Written Representation – Deadline 6

Planning Inspectorate Reference EN020027 – Norwich to Tilbury

Response to National Grid's Document 8.4.12.2 (Response to ISH2 Action Point 27 – Masterplans),
Appendix A – Waveney Valley, including Snow Street, Roydon, Roydon Fen and Wortham Ling

Submitted by: [REDACTED] – resident, Roydon, Norfolk

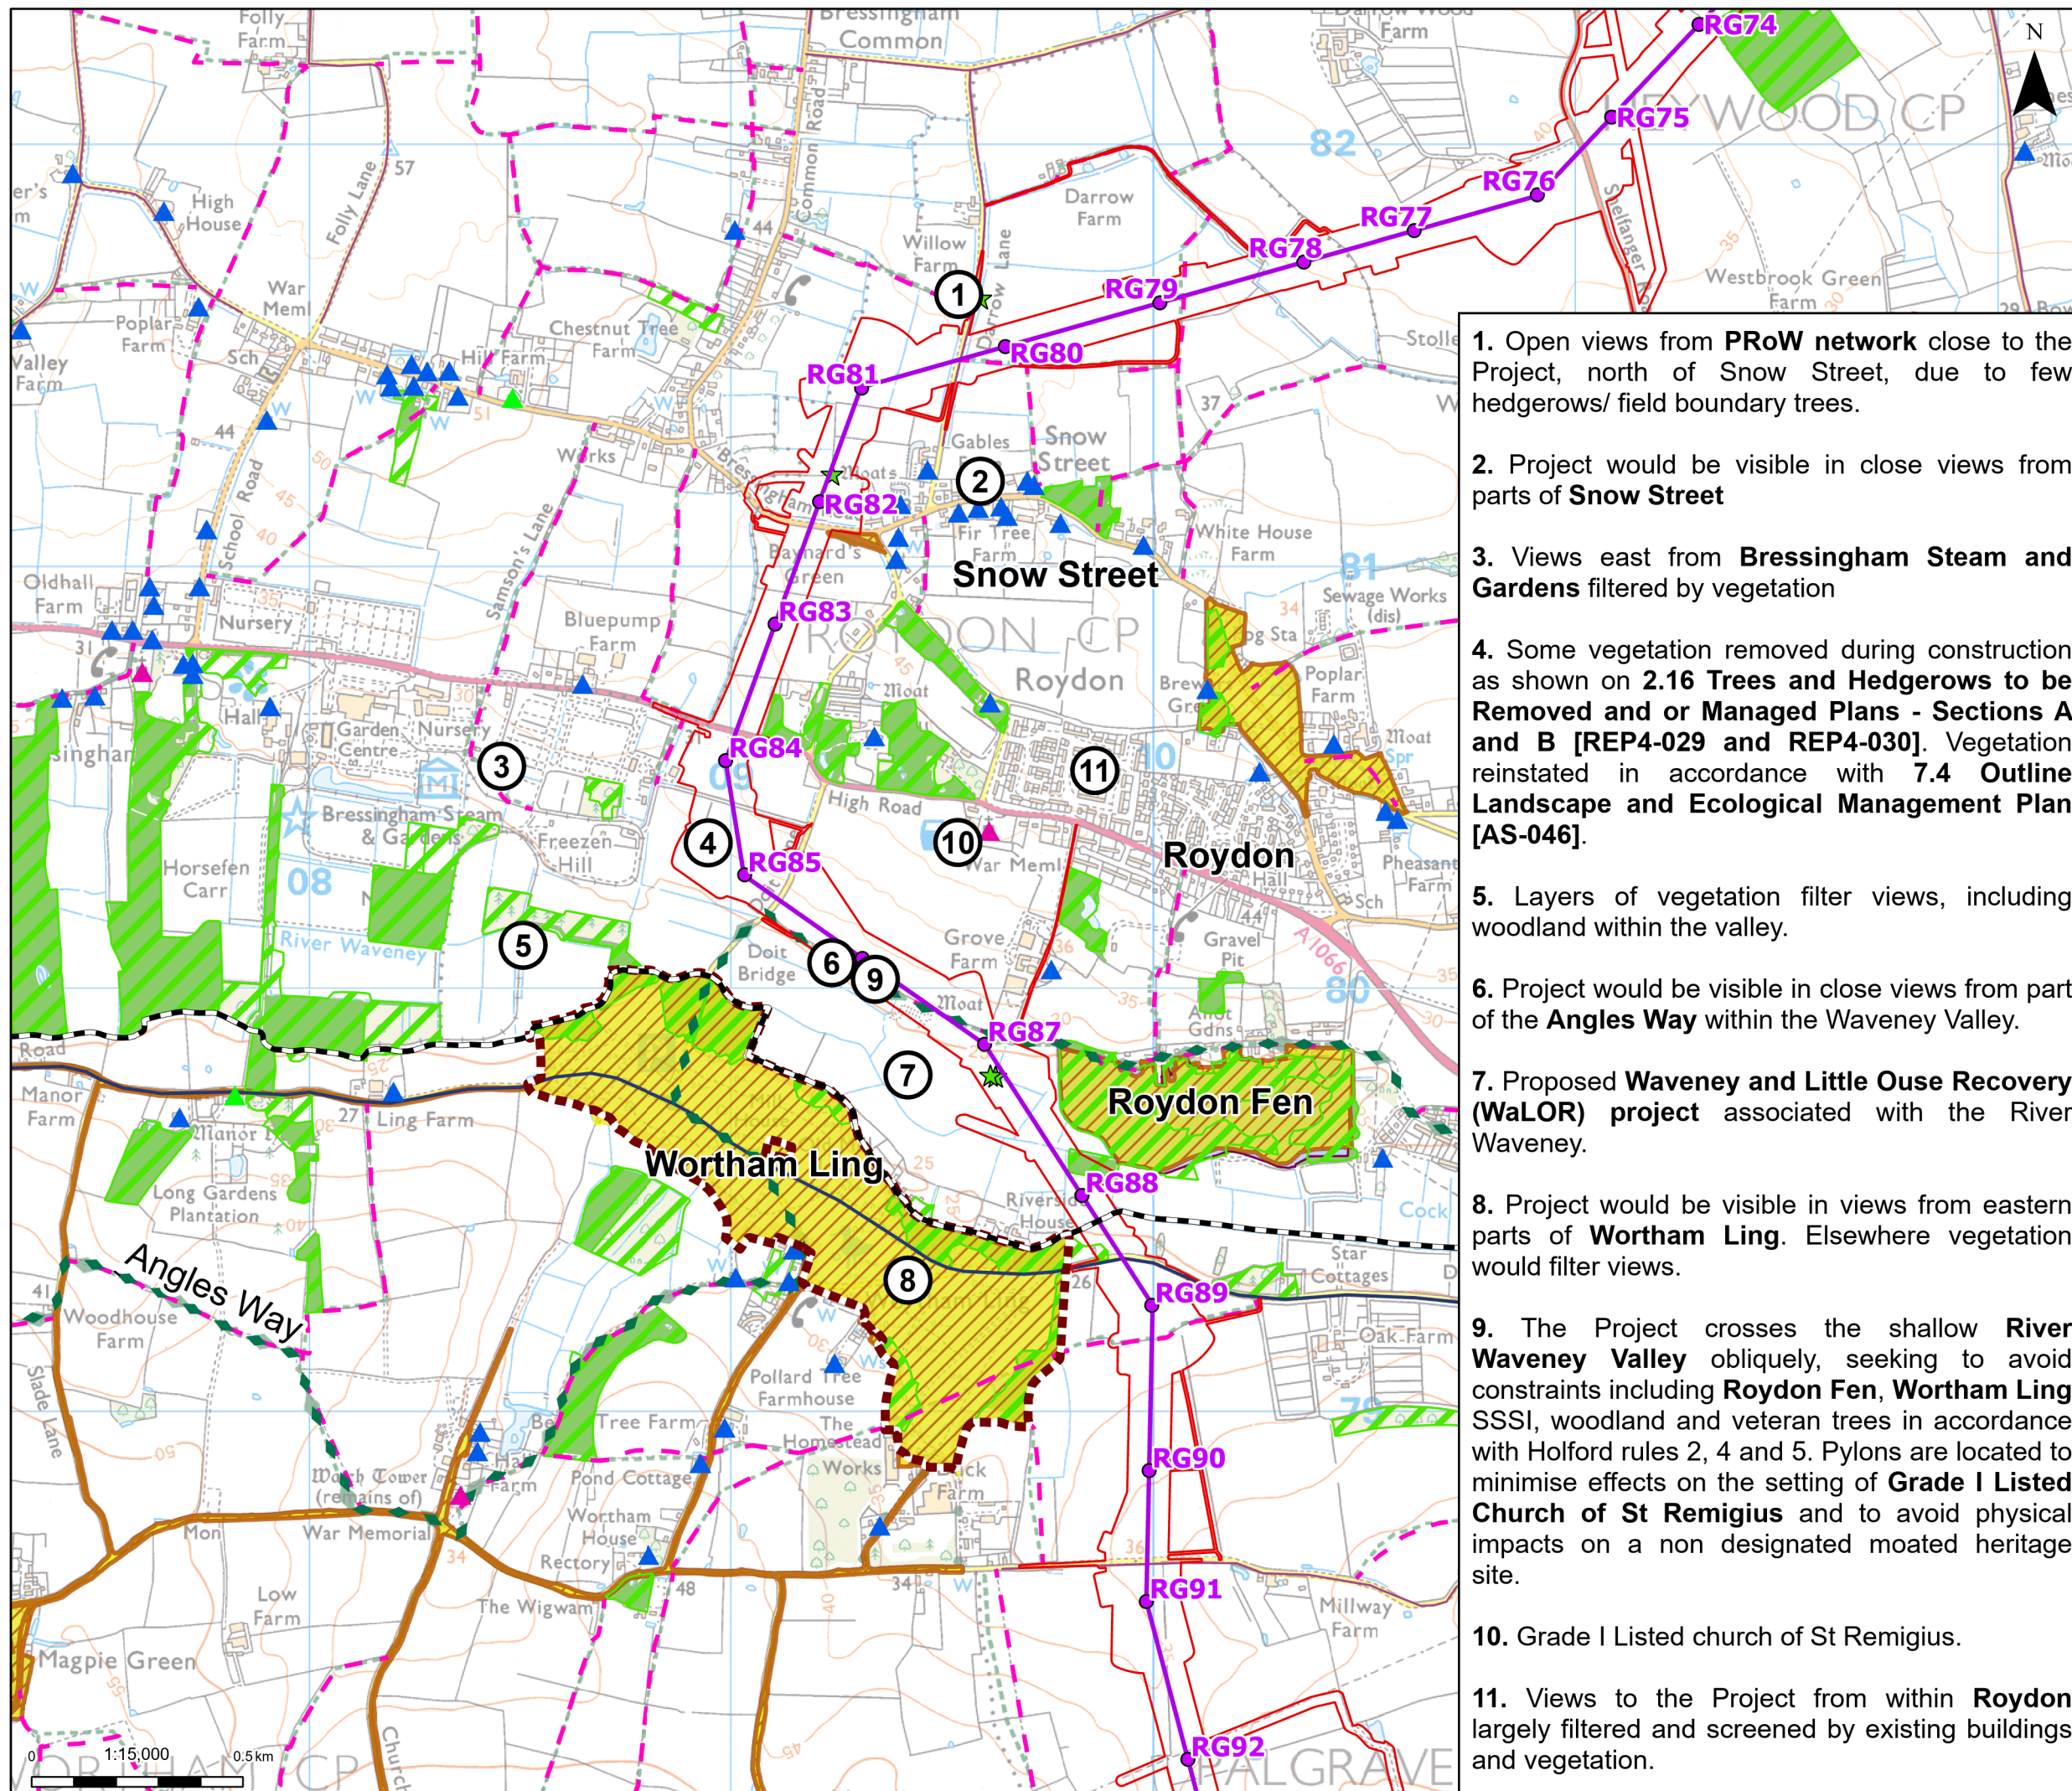
Points 1 to 3 cover the northern approach, around Snow Street. Point 1 admits there are “few hedgerows/field boundary trees” north of Snow Street — in other words, National Grid's own document accepts there is nothing to screen the pylons along this stretch. Point 2 confirms the Project will be visible in close views from Snow Street itself, which is the historic heart of the village described above. Point 3 notes that views east from Bressingham Steam and Gardens are filtered by vegetation — which tells you mitigation has been actively thought through for the museum, a site connected to why the route changed in the first place.

Point 4 says vegetation removed during construction will be reinstated under a couple of cross-referenced management plans. What it does not say is what will actually be planted, where, how dense, or how long it would take to grow — and it says nothing about whether any of this would do anything for the tower nearest the village, RG85. As it stands, this is a generic reference to a plan, not a specific answer to a specific problem.

Point 5 says layers of vegetation, including woodland in the valley, filter views. I know this stretch of ground, and that is not what is there. There are no properties in front of or behind this section, and no woodland to filter anything. From the village, this stretch offers no cover at all.

Points 6 to 8 all concede visibility without offering anything in return. Point 6 admits the Project will be visible from part of the Angles Way — an ancient route above the valley that is well used by walkers — but proposes nothing to address it. I have looked at the Holford Rules and they do not contain a specific rule about named footpaths or trails; the closest is Rule 2, which requires high-amenity areas to be avoided by deviation. No deviation is offered here. Point 7 refers to the Waveney and Little Ouse Recovery project (WaLOR) as though it were relevant mitigation. It is not National Grid's project. It is an existing, independently funded DEFRA scheme, run by Suffolk Wildlife Trust and the Environment Agency, covering over 1,600 hectares between Diss and Thetford, still in its development phase, aimed at river and fen restoration — nothing to do with landscape or visual harm, and nothing National Grid is funding or delivering. Point 8 concedes visibility from parts of Wortham Ling, a nationally protected SSSI, again without proposing anything specific.

Point 9 claims the pylons are sited to minimise effects on Roydon Fen, Wortham Ling and St Remigius Church “in accordance with Holford rules 2, 4 and 5.” I deal with that claim properly below, because I don't think it stands up.

Point 10 is worth quoting in full, because that is all it says: “Grade I Listed church of St Remigius.” That's it. Every other point on this plan has a sentence describing the effect and what, if anything, is proposed. Point 10 doesn't. Having checked National Grid's own reference map, pylons RG85, RG86 and RG87 sit directly in view of the church — both looking from the valley toward the church, and looking from the church out across the valley. National Grid offers nothing here to protect either view, even though this is exactly the harm Historic England raised at the hearing. By contrast, National Grid's own wider Environmental Statement gives Bressingham Steam Museum a dedicated numbered viewpoint, Viewpoint 1.19, with its

Point 11 says views from within Roydon are “largely filtered and screened by existing buildings and vegetation.” That does not sit alongside Points 1, 5 and 9, which all concede open, unscreened views, and it does not sit alongside what nearly the whole village told us in our own survey.

Point 9 of National Grid's constraints plan says the route has been designed “in accordance with Holford rules 2, 4 and 5” to minimise effects on Roydon Fen, Wortham Ling and St Remigius Church. Set against the rules themselves, I don't think this claim holds up.

The route doesn't avoid Wortham Ling and Roydon Fen. It runs between them, through a narrow gap, and it doesn't avoid the setting of the church either. Threading a line between two protected sites is not what Rule 2 means by avoidance.

National Grid's own Point 1 admits there is barely any vegetation to provide a background at all on this stretch. The rule's central requirement is conceded as unmet in National Grid's own document.

This stretch does not meet that description. The towers here are National Grid's own standard height for this project — 50 metres, spaced roughly 350 metres apart. From Snow Street through to Darrow Lane the land is flat, open arable farmland, with no woodland and no landform to break up a structure of that height, and nothing beyond hedgerow-scale trees — oaks and field maples, nowhere near 50 metres — anywhere near it. Approaching the village around RG83 to RG74, the towers are visible from open ground in every direction, with nothing to screen them. The Diss & District Neighbourhood Plan's own Key View 28 describes this same stretch, Darrow Lane, as “one of the few open, agricultural, big sky landscapes in Roydon” — the same absence of cover Rule 5 is meant to guard against.

Action Point 27: Waveney Valley – Draft Opportunities Plan

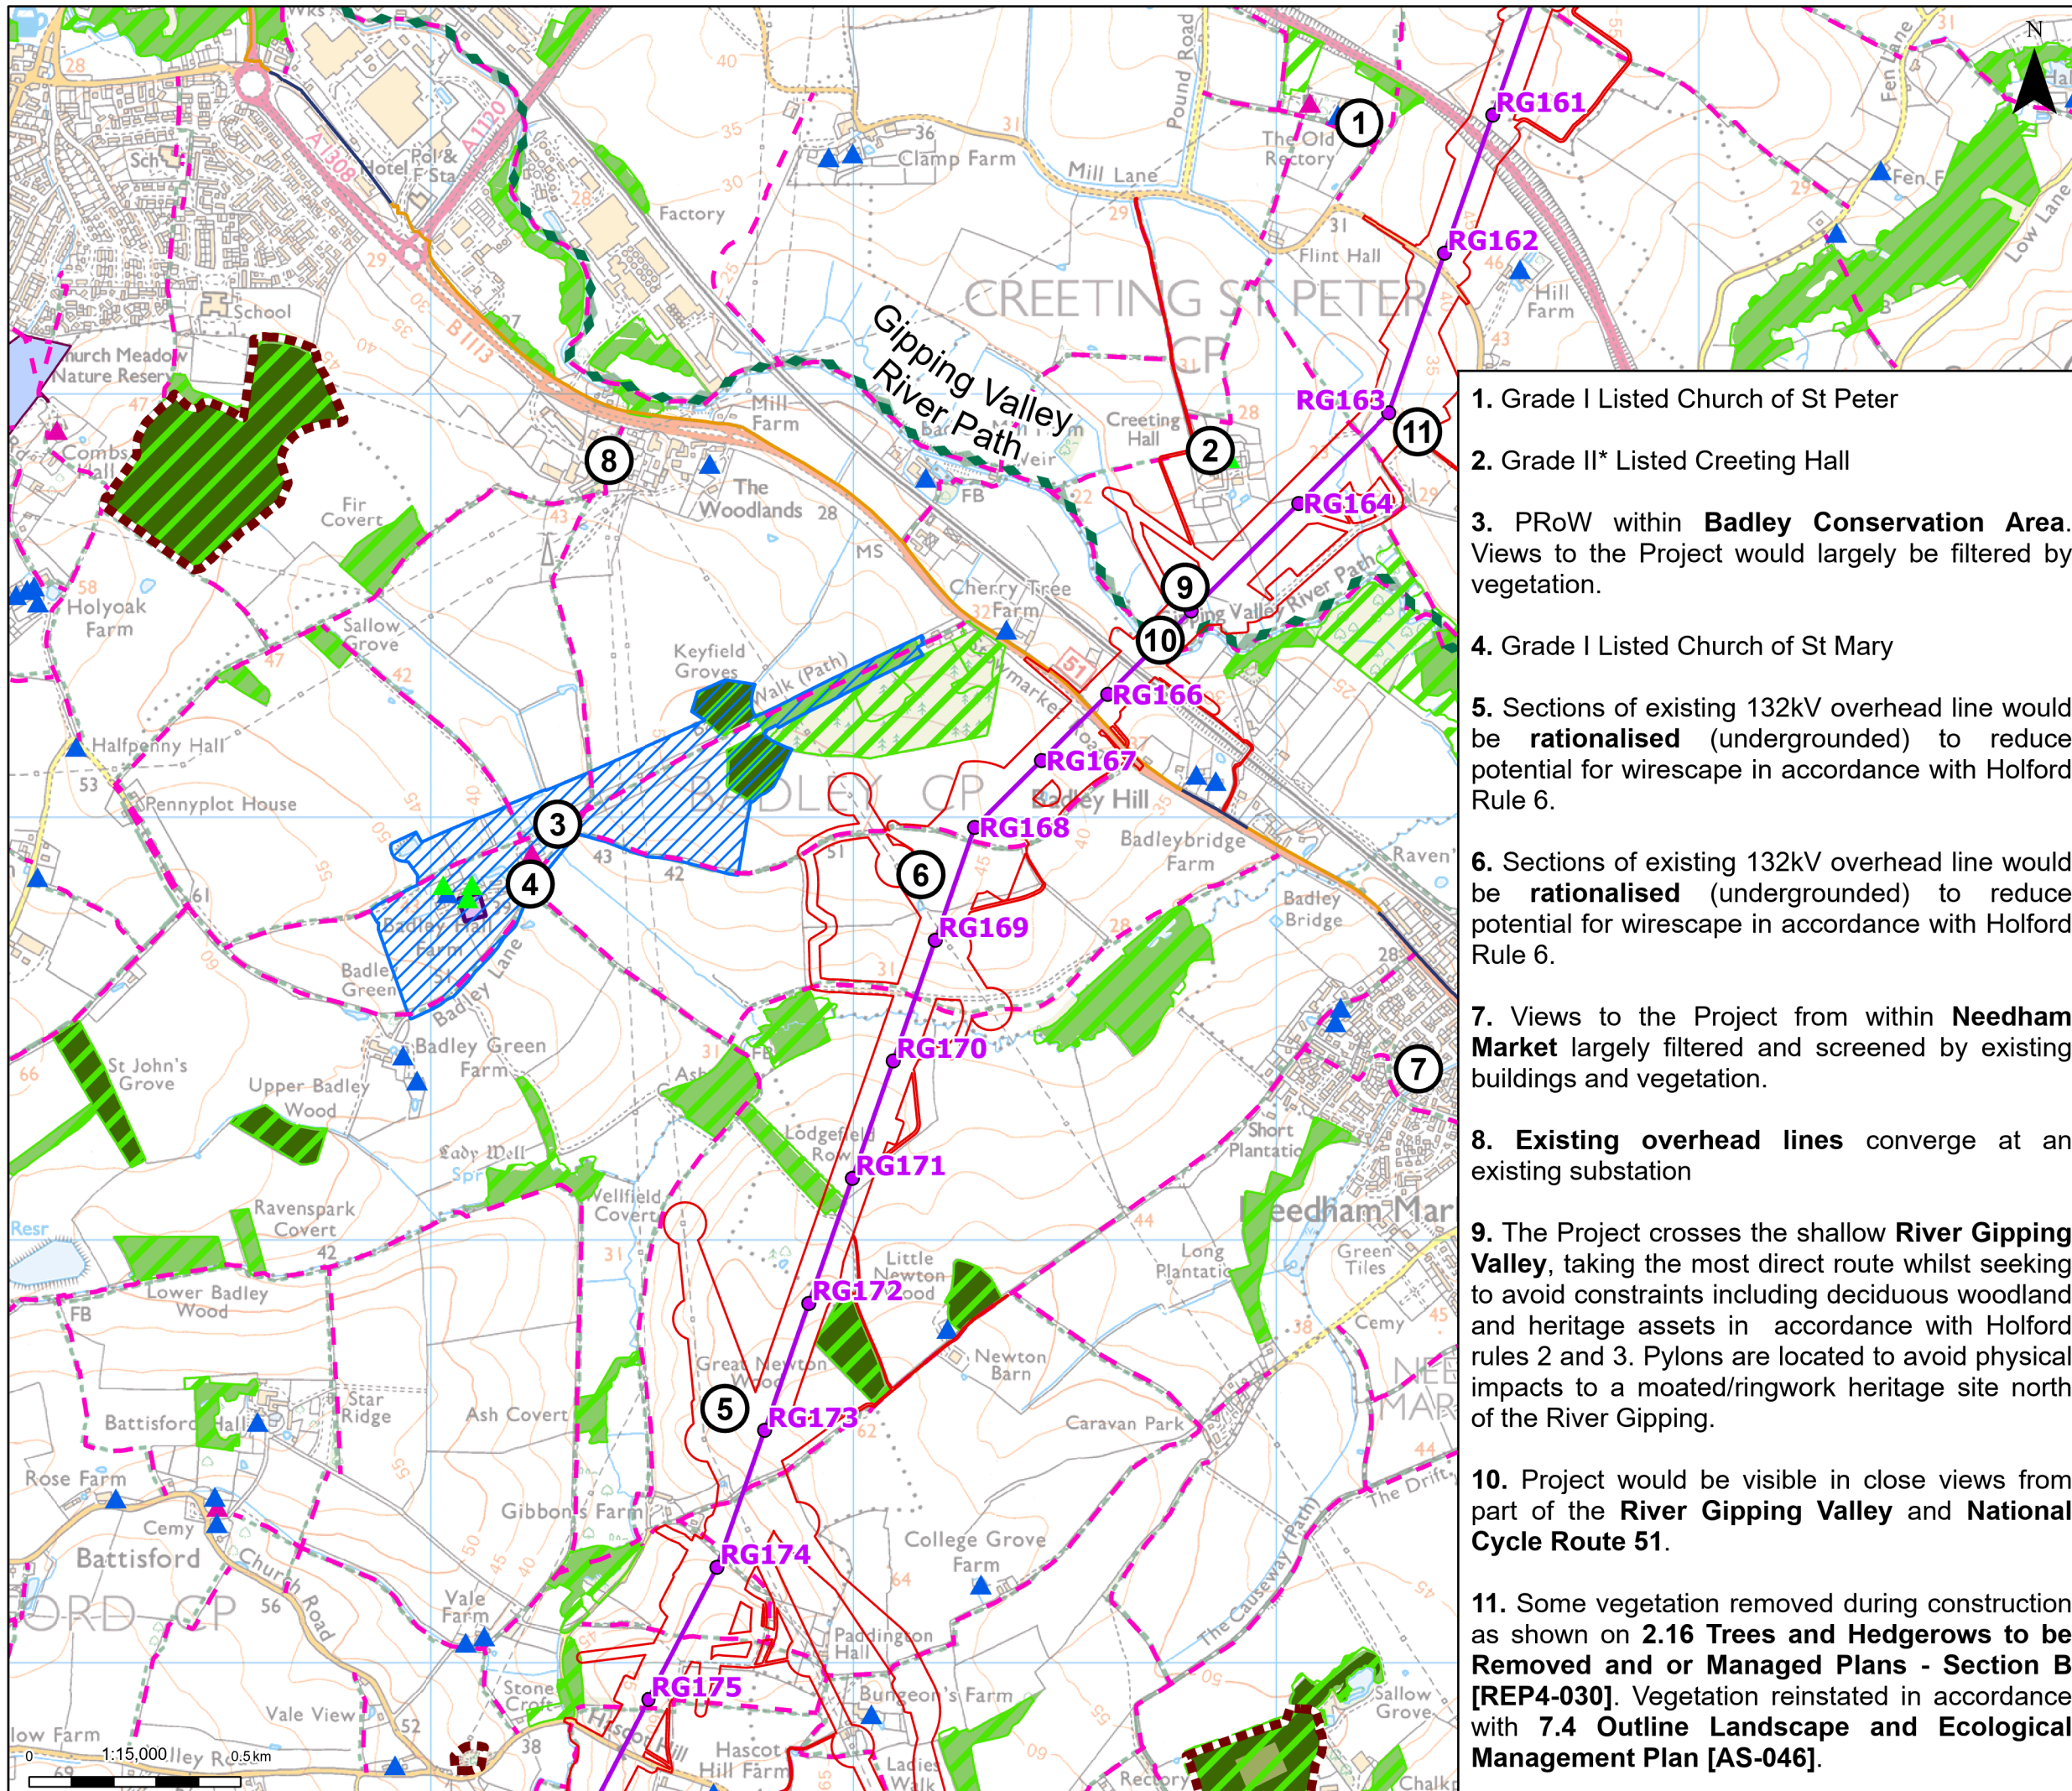
I have looked at the accompanying opportunities plan against what is actually at stake here — the heritage, the protected sites, the amenities — and there is very little in it for Roydon.

The stretch from roughly RG81 down to RG75, across open, flat fields, matches exactly what Point 1 already admits: no screening. And there is nothing marked as an opportunity anywhere along that stretch. Equally, nothing at all is shown along the back of Baynard's Green and Snow Street, which is where the impact on the historic core of the village is felt most.

Where opportunities are shown, several sit in the middle of fields that are actively farmed — marked as “links to Local Nature Recovery Strategy areas” or “connective green infrastructure enhancements.” National Grid's own document says, at paragraph 2.6.1, that no discussions have yet been held with the relevant landowners. So there is no reason to think any farmer has agreed to any of this. It's a drawing on a map, not an arrangement with anyone who owns the land.

Nor does the plan deal with the change of direction in the route east of Wortham Ling. This has been reported as a 90-degree turn as the alignment comes down from the area of Doits Lane into the Waveney Valley floor — National Grid's own Route Drive Site Visit Guidance Document confirms the alignment crosses ‘The Doit’ at this point. A turn like that needs an angle tower — exactly the kind of more massive structure Holford Rule 3 says a route should avoid by staying as direct as possible. National Grid's plan says nothing about this. Suffolk County Council has raised the same principle elsewhere on this route, at Gislingham, where the alignment changes direction four times and crosses Burgate Road twice; the Council's own representation to this Examination states this “is likely to result in significant adverse effects and disbenefits for the visual amenity along this route, which is used for recreation.” The same reasoning applies here.

The plan also marks an area between Roydon Fen and Wortham Ling as an “opportunity to support enhancements proposed by the WaLOR project.” As above, WaLOR is someone else's project, not National Grid's. And at this point the River Waveney is close to its source — it rises a short distance to the west at Redgrave and Lopham Fens and forms the boundary of Bressingham and Roydon before it even reaches Diss. I know this stretch of river, and it is a small headwater watercourse here, nothing like the river further downstream. There is only so much a “blue infrastructure enhancement” can do on a stream this size, and National Grid hasn't said what it would actually pay for or deliver.

More to the point, National Grid's own document admits the whole opportunities plan is draft, illustrative and unfunded, and states plainly that it “would not materially change the ES assessment of landscape and visual effects” even if it were all delivered (paragraph 2.4.1). Most of it sits outside the Order Limits, on land National Grid does not own or control, with no landowner discussions held (paragraph 2.6.1), and delivery would depend entirely on voluntary agreement. On National Grid's own account, this plan is not secured
